## **Development Facilitation Team (DFT) – Review Comments**

**Project No: PR-2023-009609**

### **Application For: SD-2024-00025 – PRELIMINARY/FINAL PLAT**

**Project Name:** Lots 14-A & 15-A, Highland Place Addition

**PLAT OF LOTS 14-A & 15-A  
HIGHLAND PLACE ADDITION**

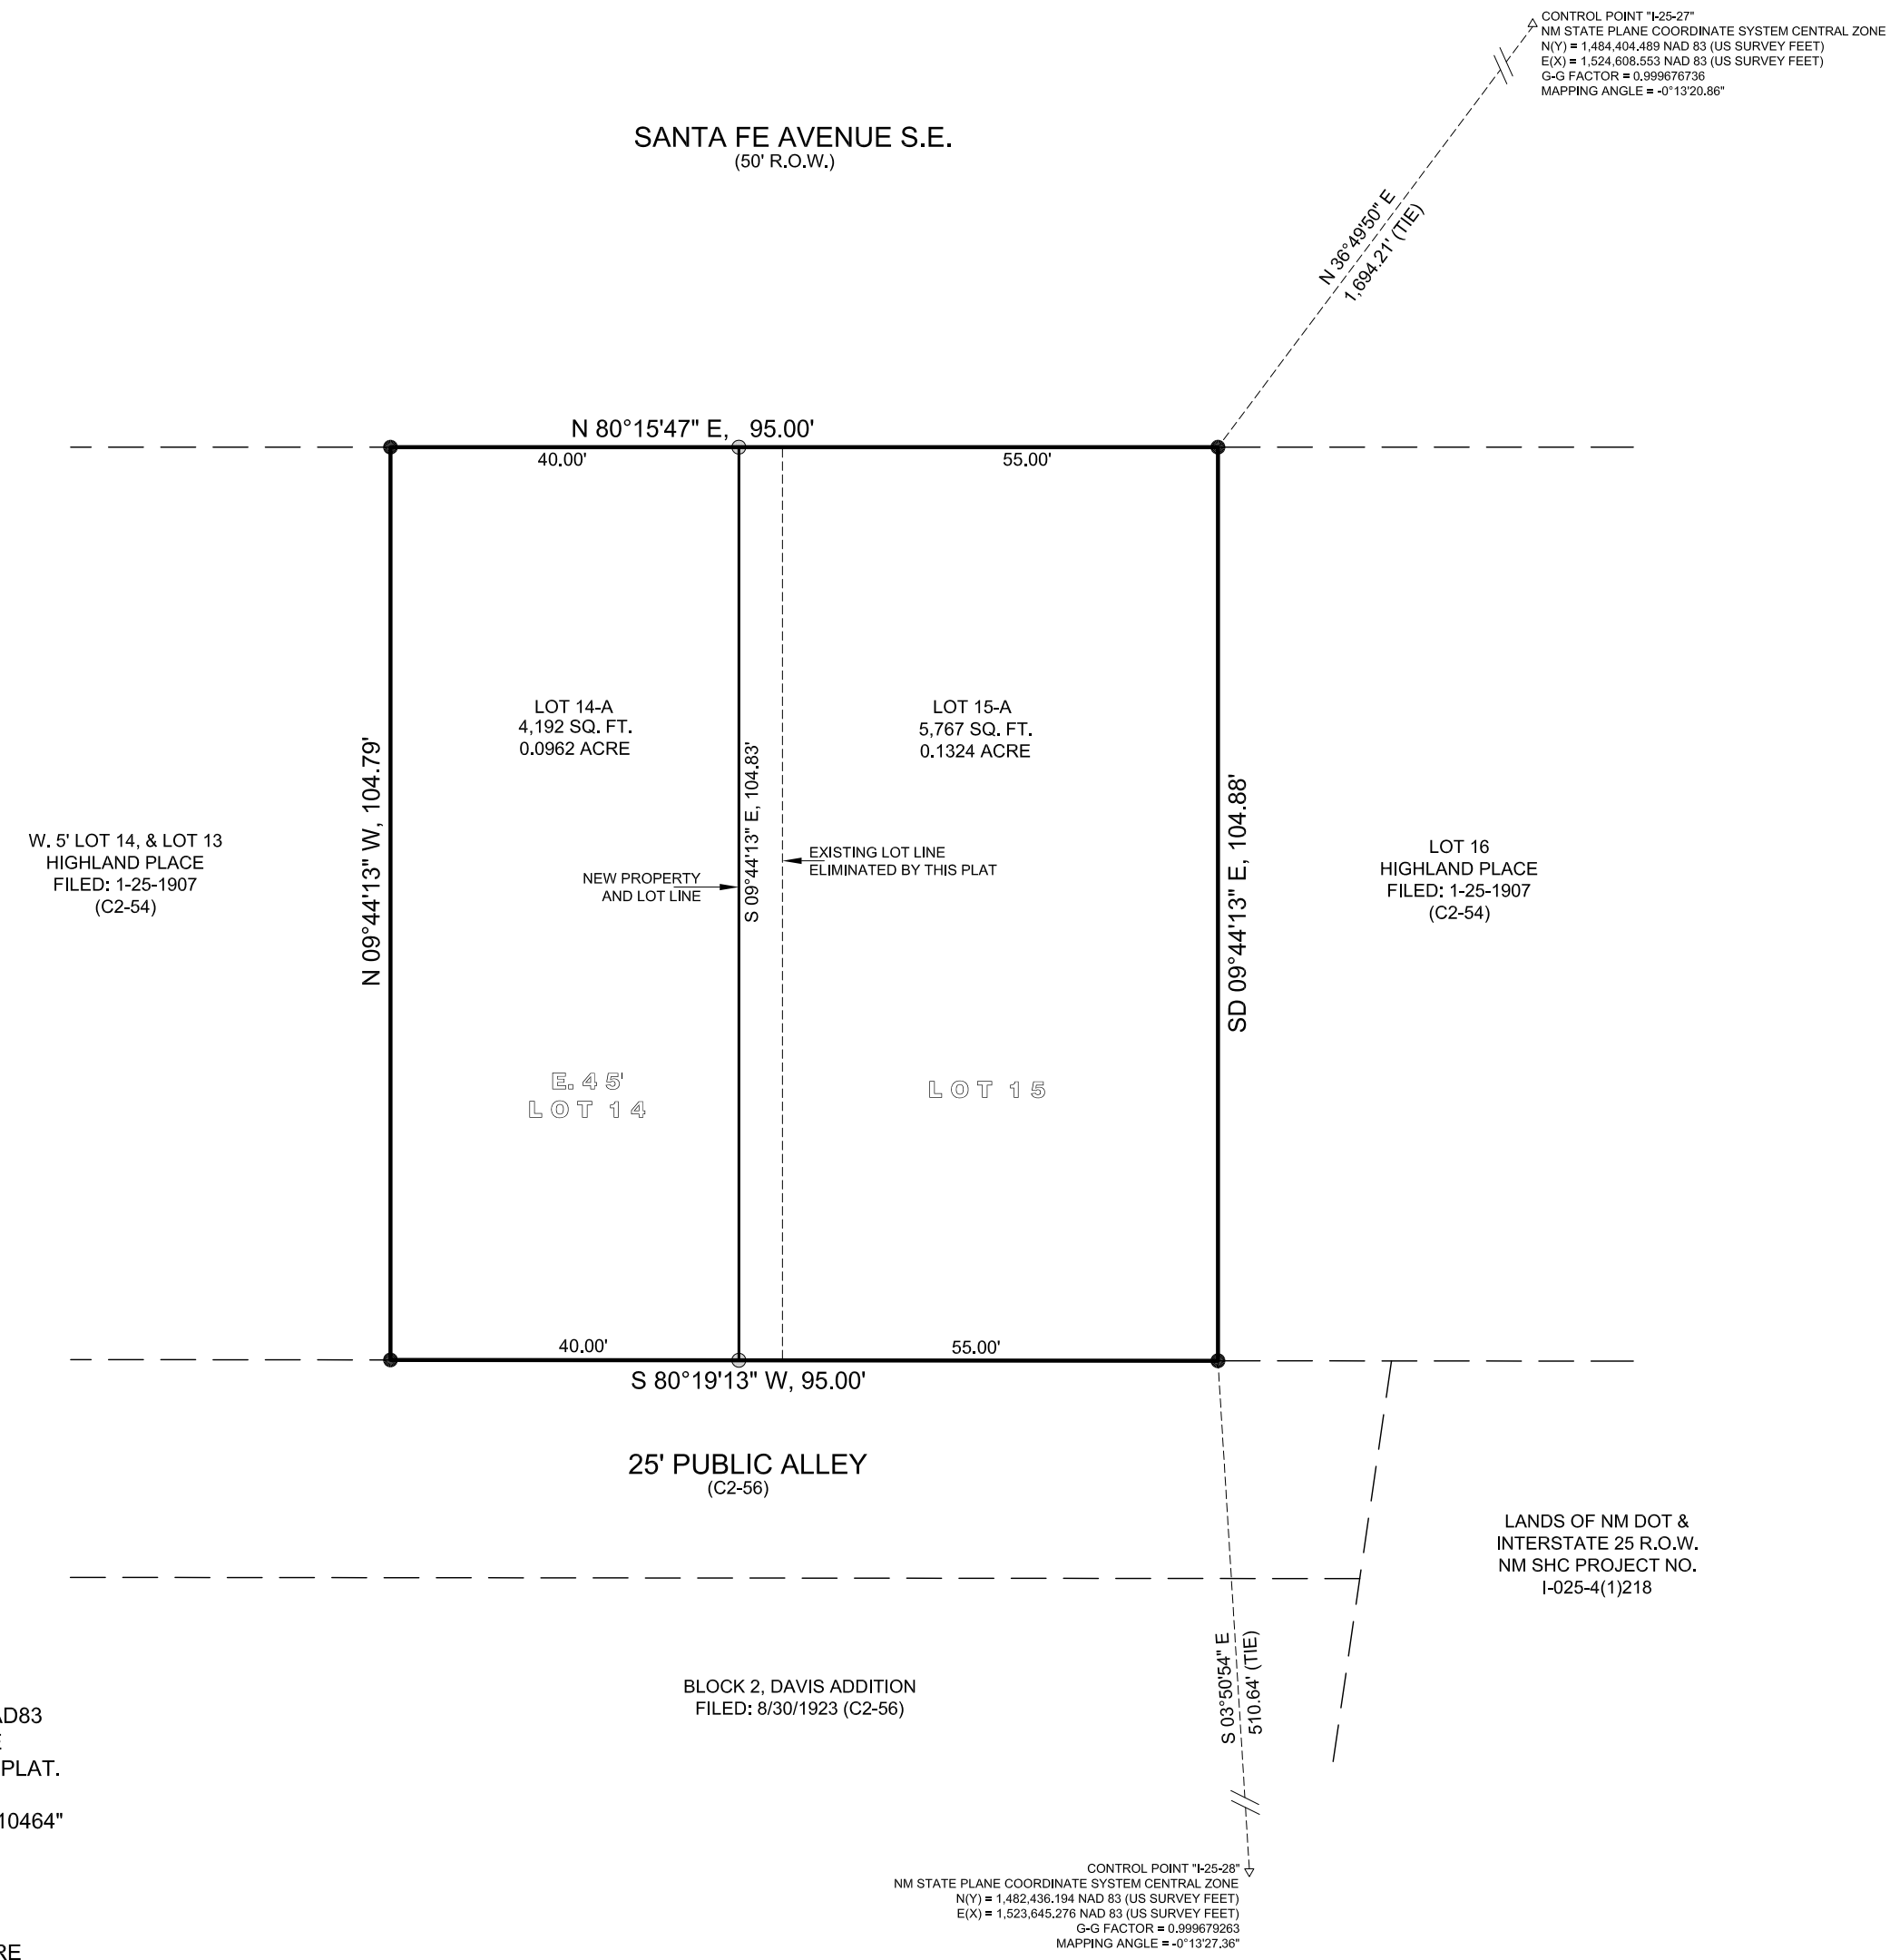
- According to property records as well as the application, Jamie & Agnes Perez, C/O GHI, Inc. owns the subject property. However, the Plat is signed by David Garcia as the owner. Proof of signatory authority must be provided that David Garcia can sign the Plat as the owner.
  - The AGIS office must approve the DXF file and proof of approval must be provided prior to final sign-off of the Plat.
  - The application number must be added to the Plat.
  - Per 6-6(L)(2)(d)(7) of the IDO, the date of the DHO approval shall be recorded on the Plat. Therefore, prior to final sign-off of the Plat, the date of the DHO approval must be added to the Plat.
  - After DHO approval and final sign off, a recorded copy of the plat must be sent to Angela Gomez at [agomez@cabq.gov](mailto:agomez@cabq.gov) and to Jay Rodenbeck at [jrodenbeck@cabq.gov](mailto:jrodenbeck@cabq.gov).
-
